NC DEPARTMENT OF  
**HEALTH AND  
HUMAN SERVICES**

May 20, 2025

RE: Chipotle Mexican Grill Store #5644  
NC 24-87  
Cameron, NC 28326

This letter acknowledges a review of the plans for the above establishment. The plans, application and specifications are approved with the following conditions:

SHEET NUMBER:
A801

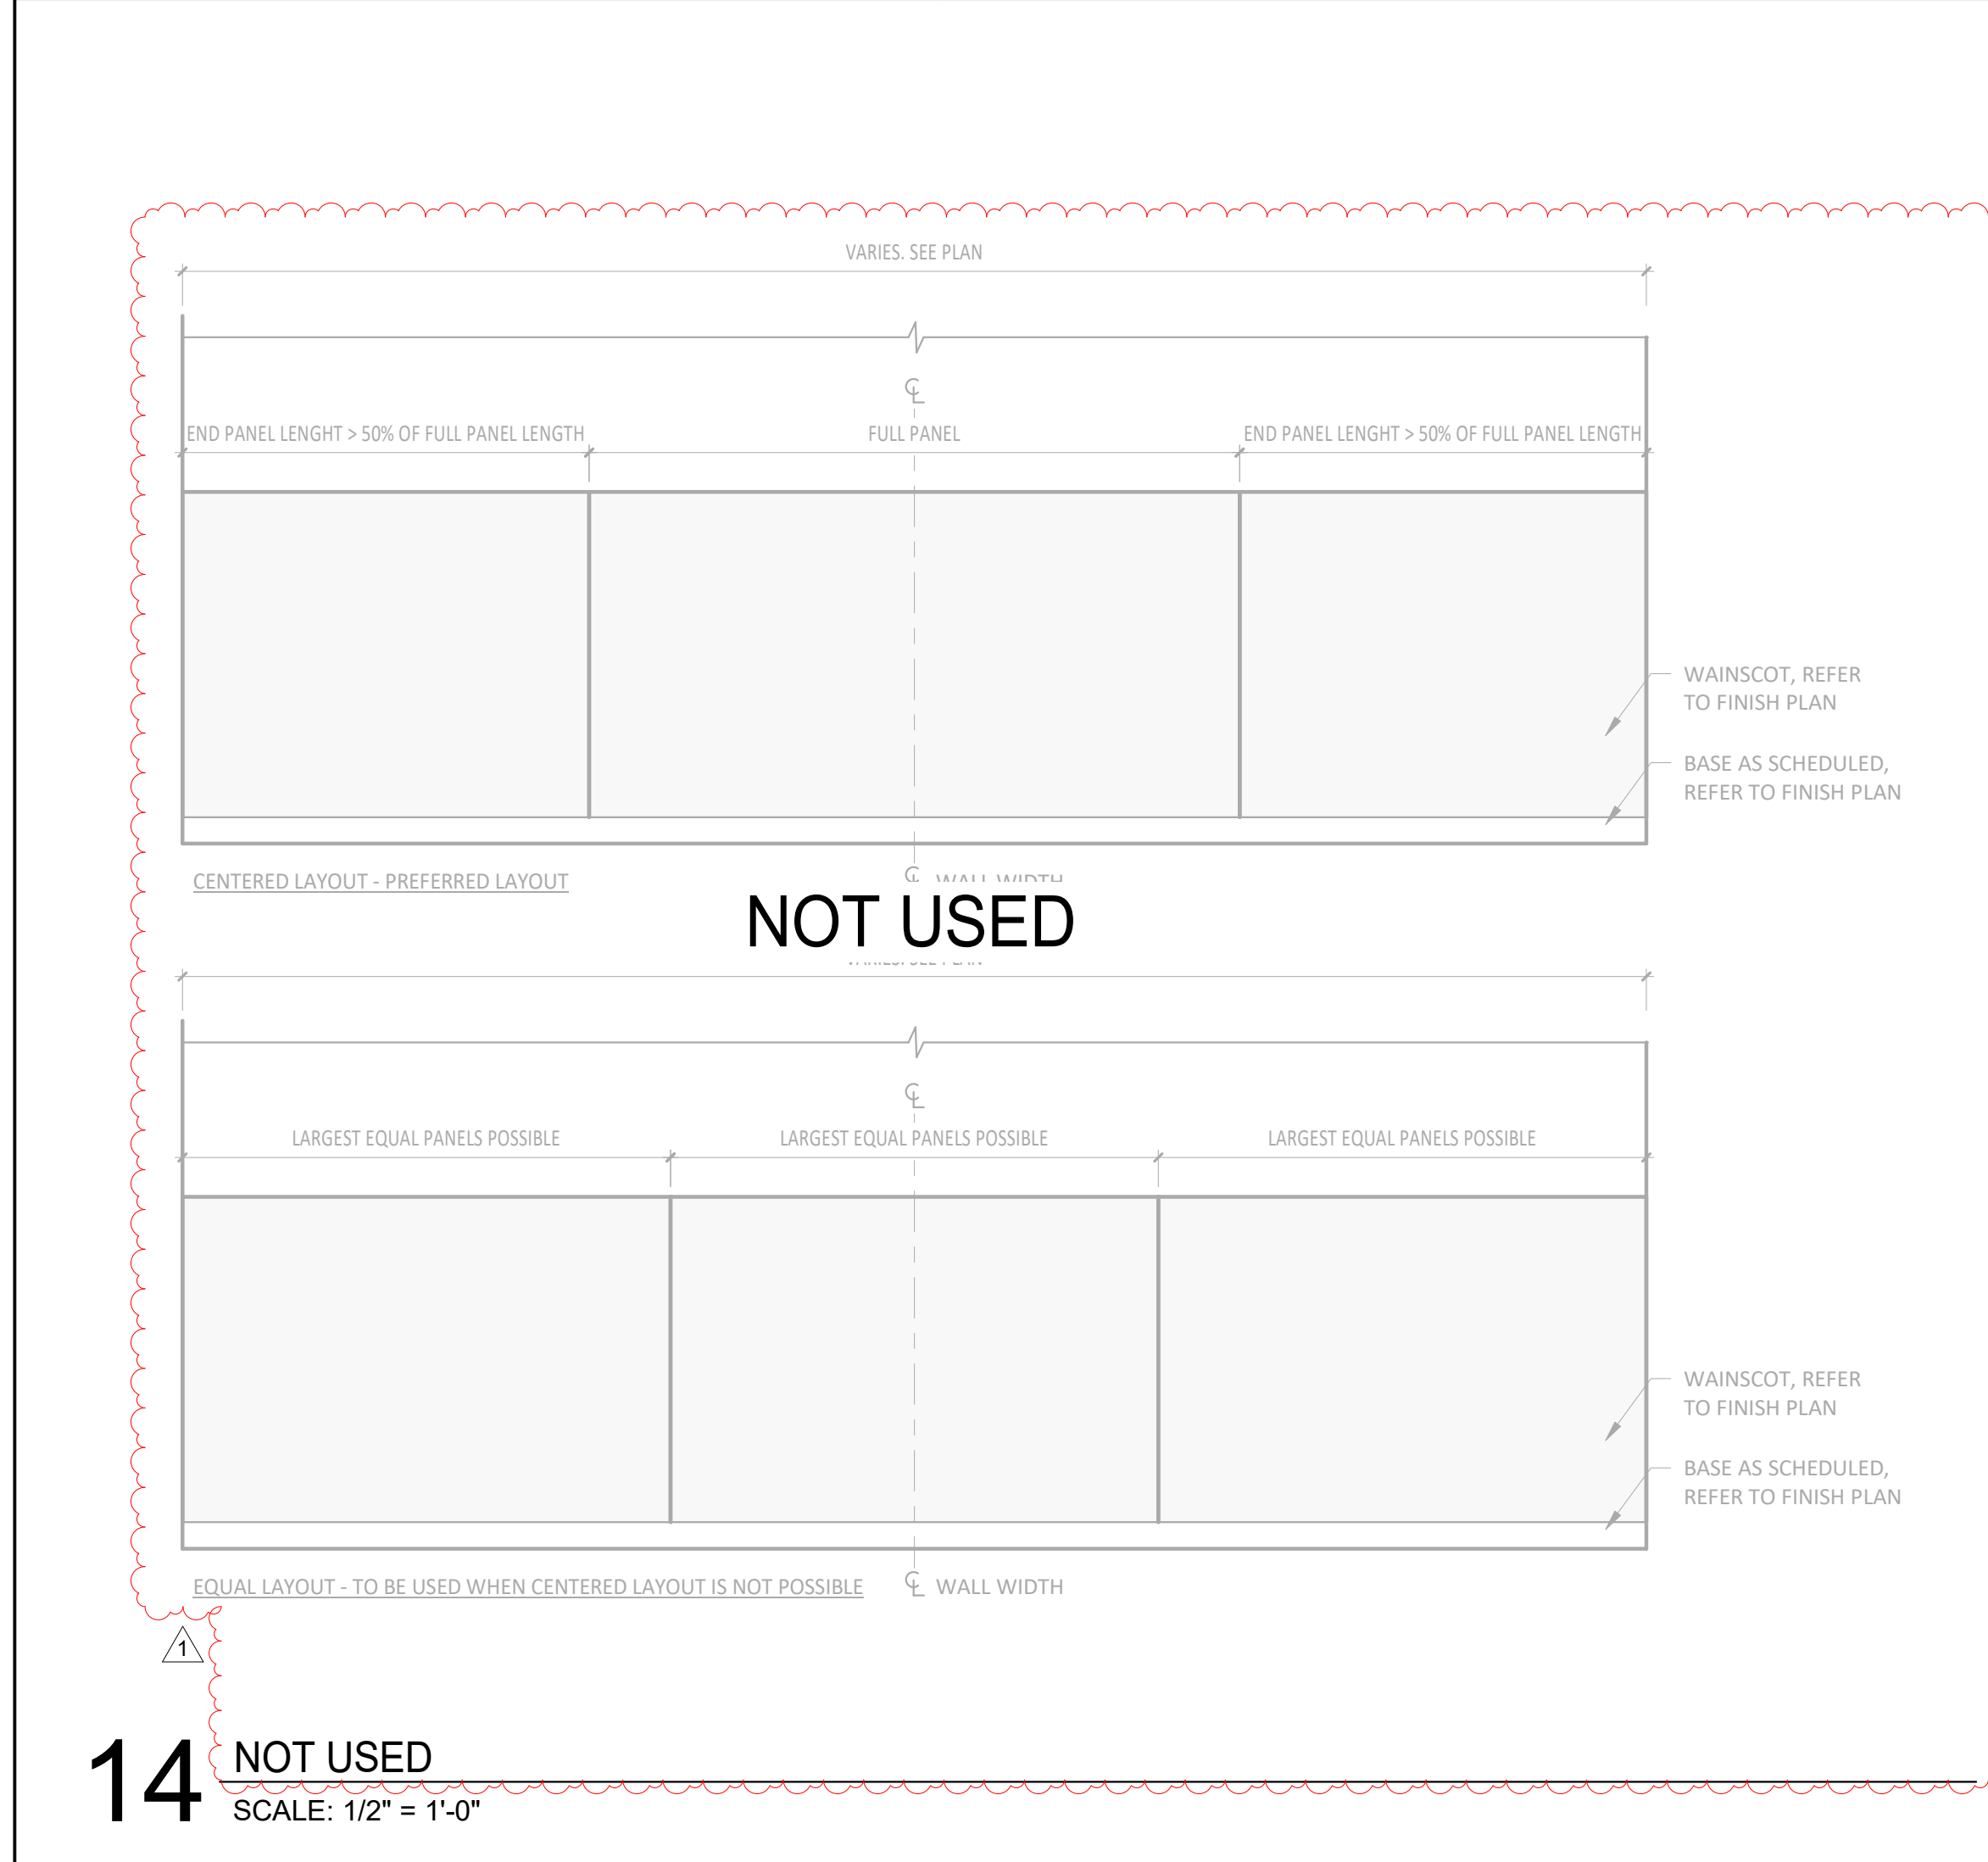
- i. The serving counter where exposed food is handled will be equipped with a sneeze guard as shown on sheet A801 detail 11 and Equipment Number 1.1 in the Kitchen Equipment Manual.
